From:
Sent: 15 January 2024 21:09
To: DCAdmin
Subject: 2023/91405 - part of former St Luke's Hospital site, Blackmoorfoot Road, Crosland Moor, HD4 5RA

**PART OF FORMER ST LUKE'S HOSPITAL SITE, BLACKMOORFOOT ROAD, CROSLAND MOOR, HUDDERSFIELD, HD4 5RA
ERECTION OF FOODSTORE (CLASS E) WITH ASSOCIATED ACCESS, PARKING, SERVICING AREA AND LANDSCAPING**

**NORTH EAST ELEVATION**

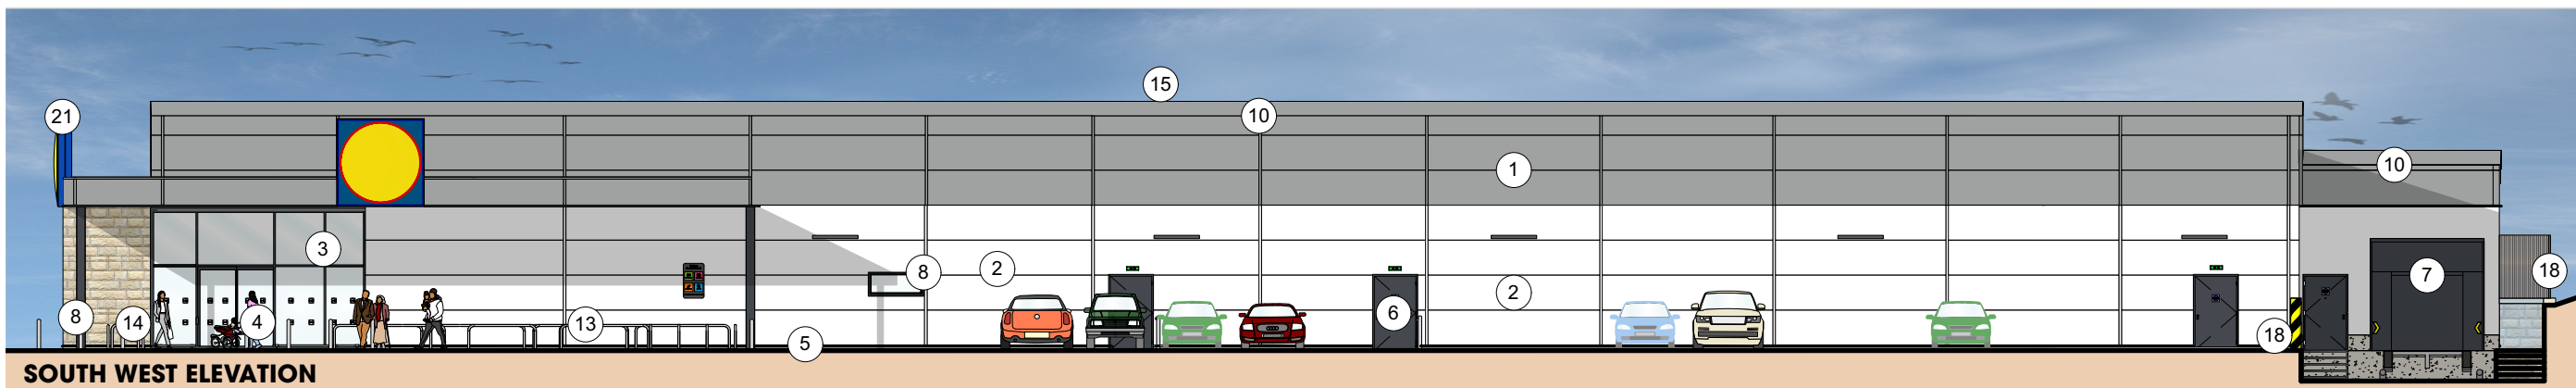
1. North east elevation - more use of stone, to prevent eyesore and to show Lidl as a quality organisation
2. attention to drainage from roof as to not overwhelm Avant homes access road and terraced houses below
3. Roof ridge level of 154 to 152 eaves - wonder/ I hope this can be lowered
4. main road safety - there is an opportunity for traffic calming measures (as previously cited). Cars speed along the Blackmoorfoot main road, often not stopping at the zebra crossing. On numerous occasions cars have sped through as we cross it.
5. As formerly mentioned, measures to stop anti-social behaviour in the car park, some kind of control over night time access to parking area, lockable gate and such.
